**HELIOS** RENEWABLE  
ENERGY  
PROJECT

**PINS Document Number:**  
EN010140/APP/6.3.9.3

**Environmental Statement  
Appendix 9.3:  
EA Consultation**

**HELIOS RENEWABLE ENERGY PROJECT – FORMAL CONSULTATION UNDER SECTION 42 OF THE PLANNING ACT 2008 (AS AMENDED) – SOUTHWEST OF THE VILLAGE OF CAMBLESFORTH, SELBY**

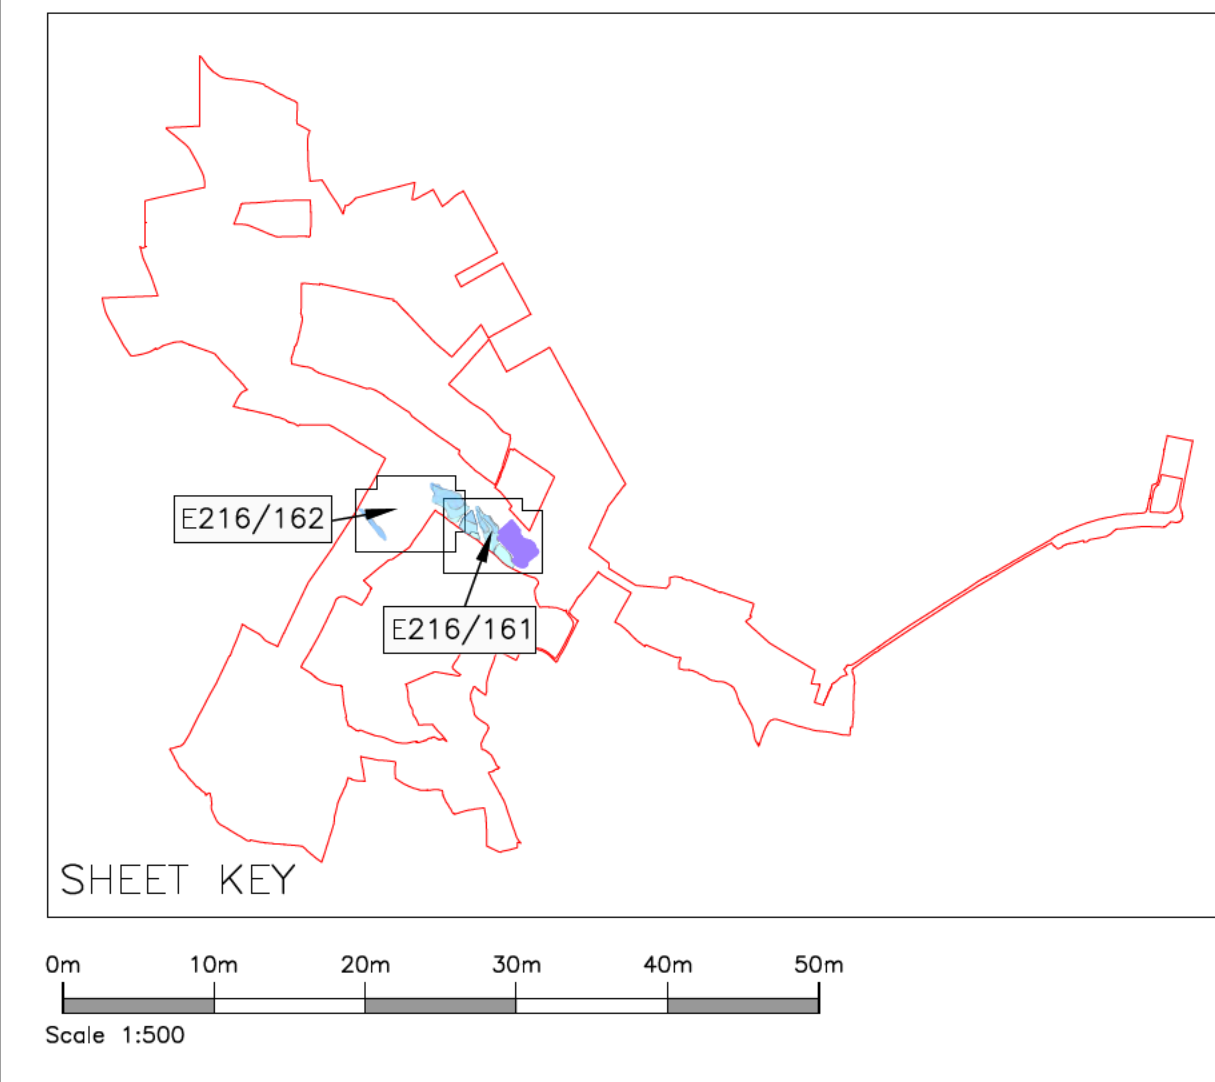
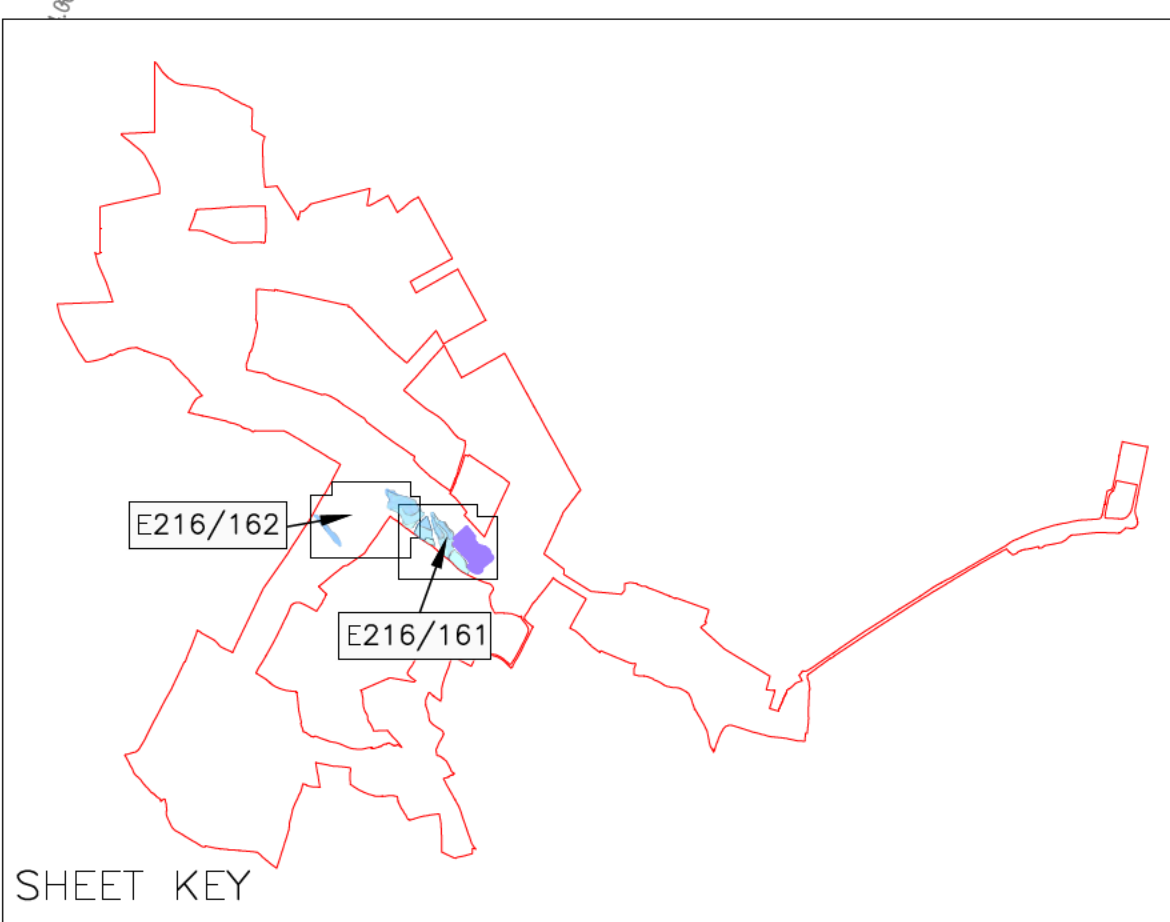
We support the assertion that level for level compensation will be provided on site to mitigate the impact of the flood bunds, but it must be noted that the assessment for the compensation required should include all relevant aspects of the development.
